PLANNING AMENDMENT

Application No. H13/0711/95

HOUSE & GARAGE, PLOT 3,
OFF ROMAN ROAD, MOULTON CHAPEL

**RESERVED MATTERS APPLICATION H13/0711/95 - HOUSE & GARAGE
PLOT 3, OFF ROMAN ROAD, MOULTON CHAPEL - DGM PROPERTIES LTD.**

SITE LAYOUT

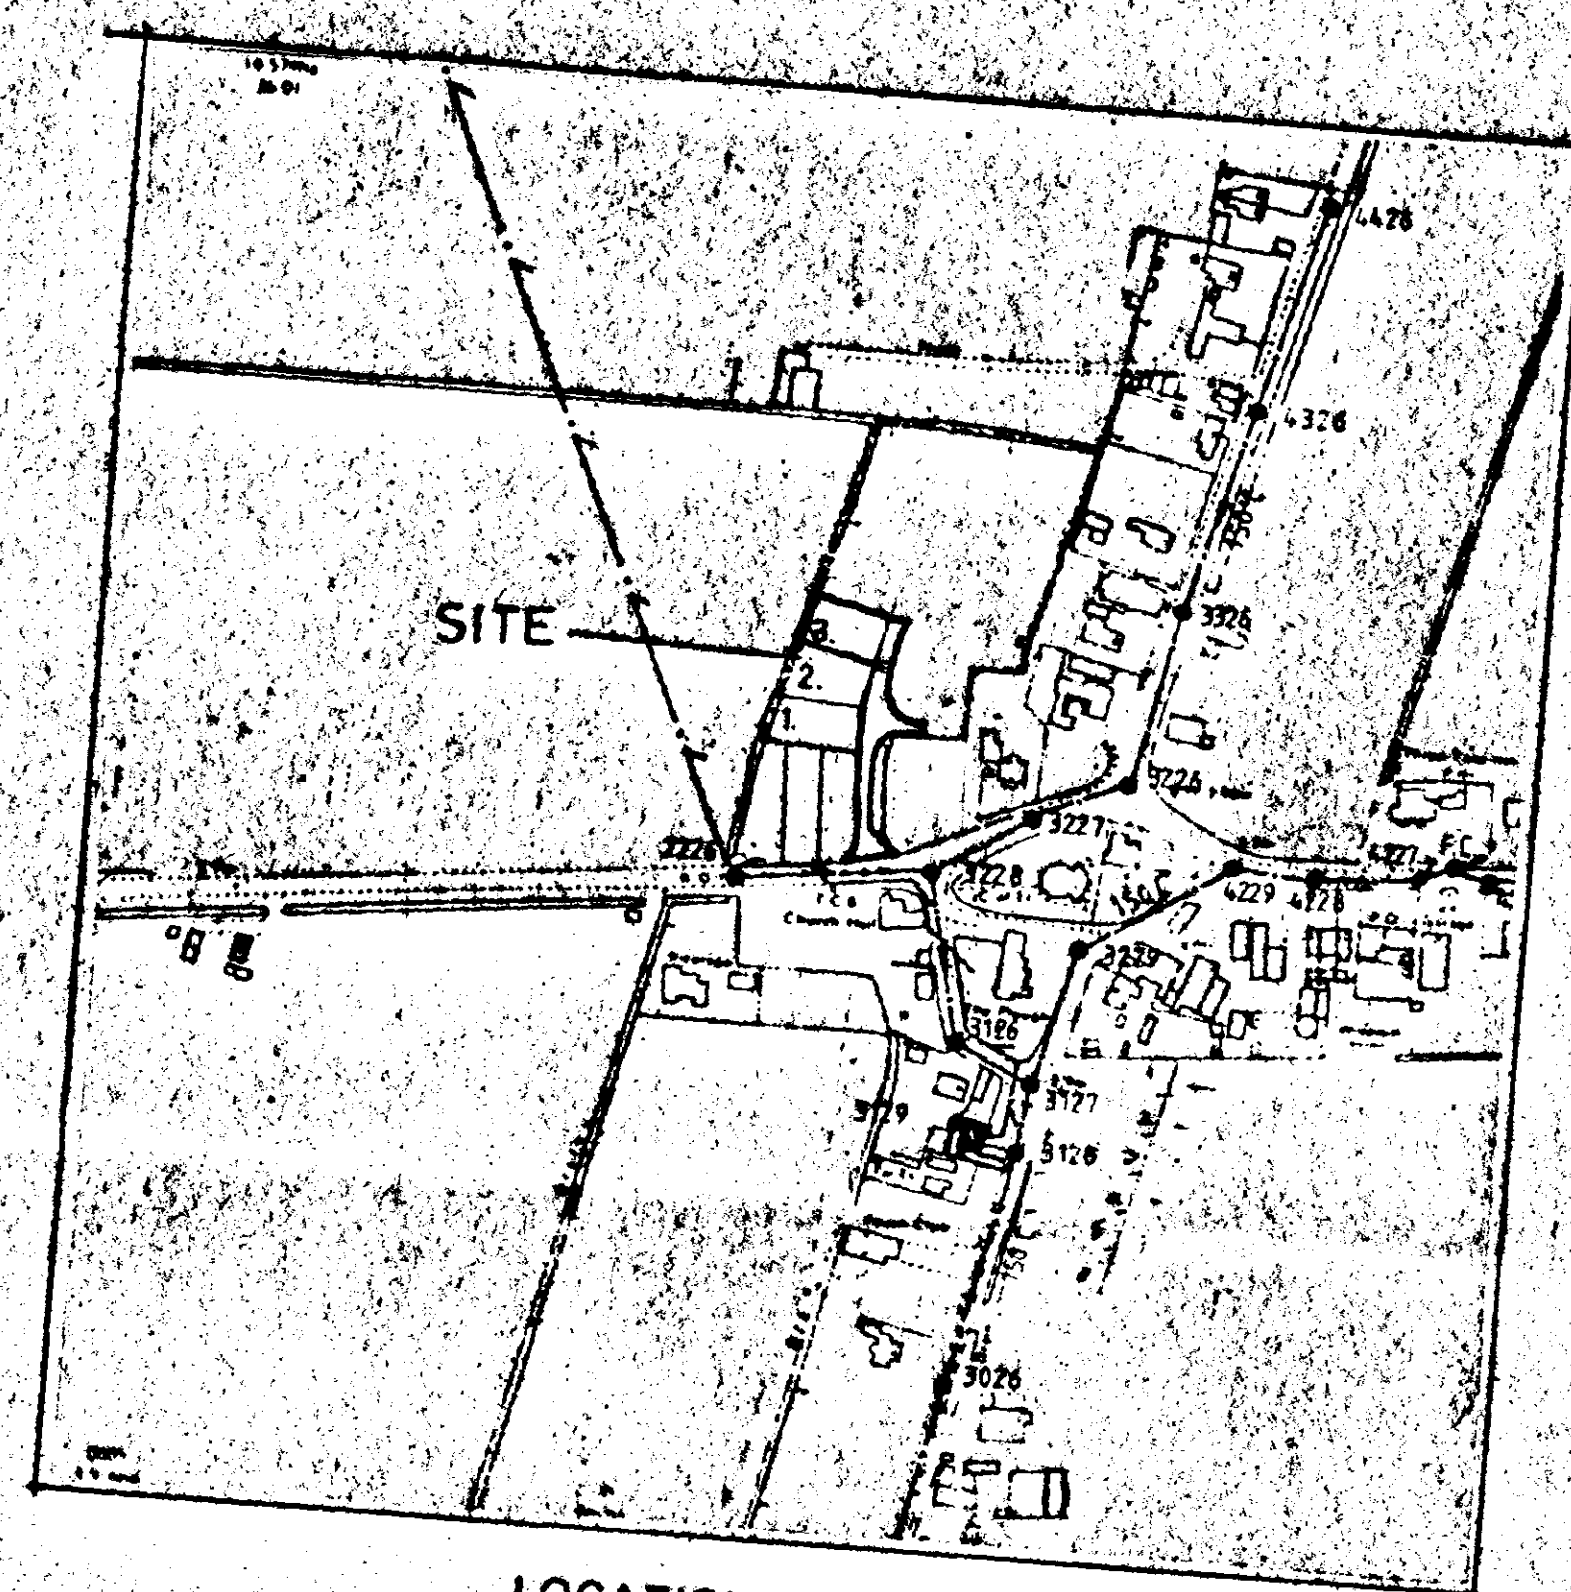
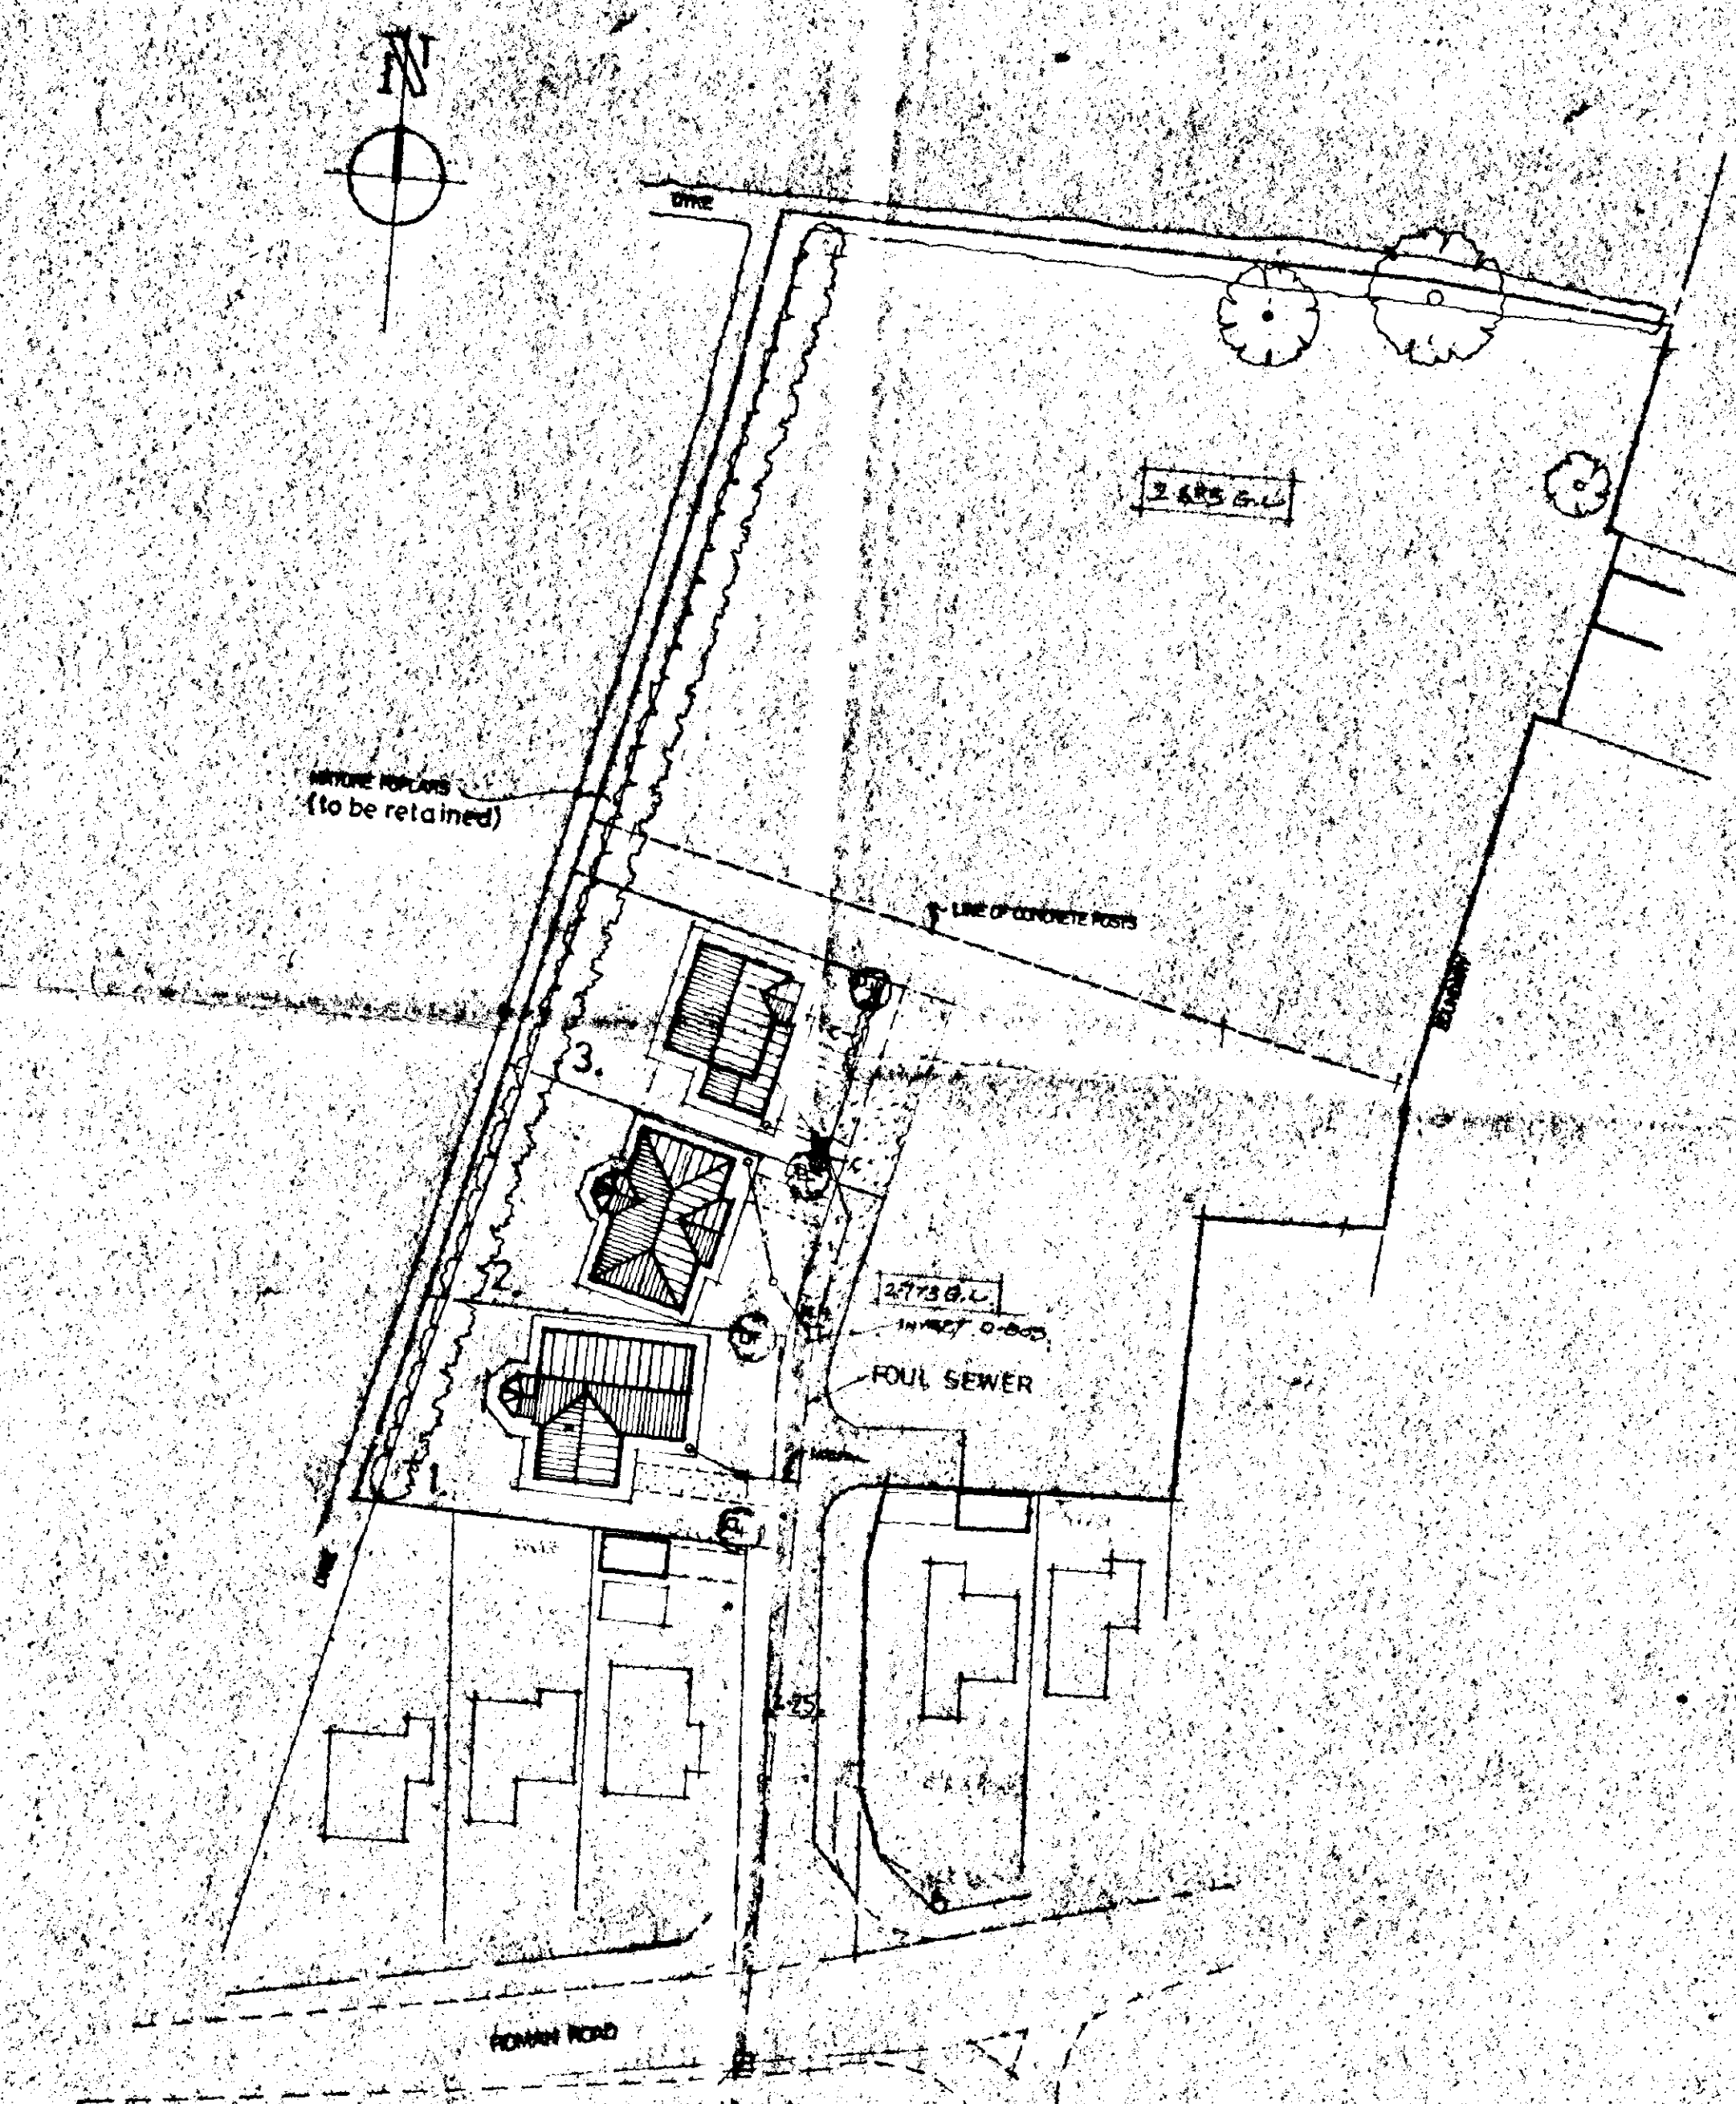
1. SOLDIER BRICKWORK ABOVE & BELOW WINDOWS
2. VERTICAL TIMBER GARAGE DOORS.
3. ADDITIONAL TREE PLANTING.

Please include the landscaping in the application for reserved matters and I have introduced a frontage beech hedge as suggested.
